9 May 2018

Our Reference: SYD15/01513/08 (A22213921)  
DP&E Ref: SSD 7388 MOD 6

**EXHIBITION OF MODIFICATION REQUEST FOR THE RIBBON, DARLING HARBOUR,  
DESIGN MODIFICATION AND EXTENSION OF CONSTRUCTION HOURS (SSD 7388 MOD 6)  
31 WHEAT ROAD, DARLING HARBOUR**

**Figure 2 Proposed roof level plan, demonstrating open roof area above pool**

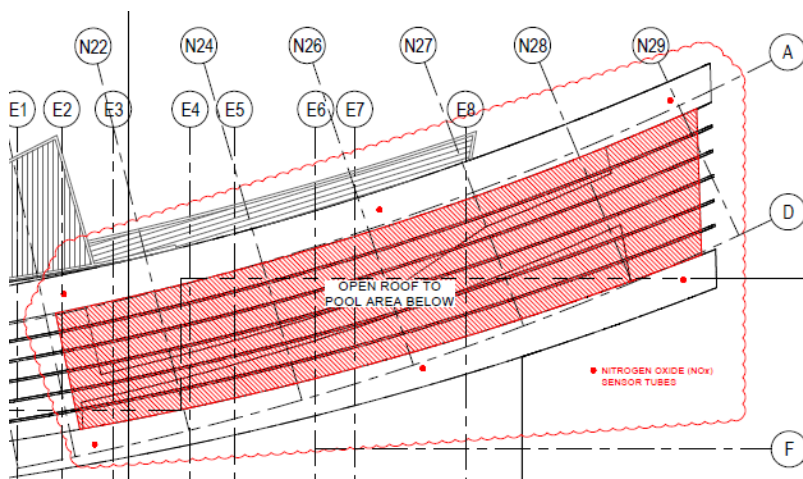
- Roads and Maritime does not support to the provision of an open air rooftop pool, a key development consent principle for all developments within 250 meters of the vent stack is for no open windows above 60 meters from ground level in order to manage the stack plume. Additionally, it is noted that the 2013 Air Quality Assessment report (attached) conducted by Pacific Environment and commissioned by the Developer, reviewed the MCoA 274 for Roads and Maritime to look at the impact of the Cross City Tunnel (CCT) Vent Stack Plume on the proposed development. In its recommendation, it states that no openings such as balconies, roof terraces and operable windows be located above 60 meters from ground level. The proposed open roof top pool is contrary with this advice.
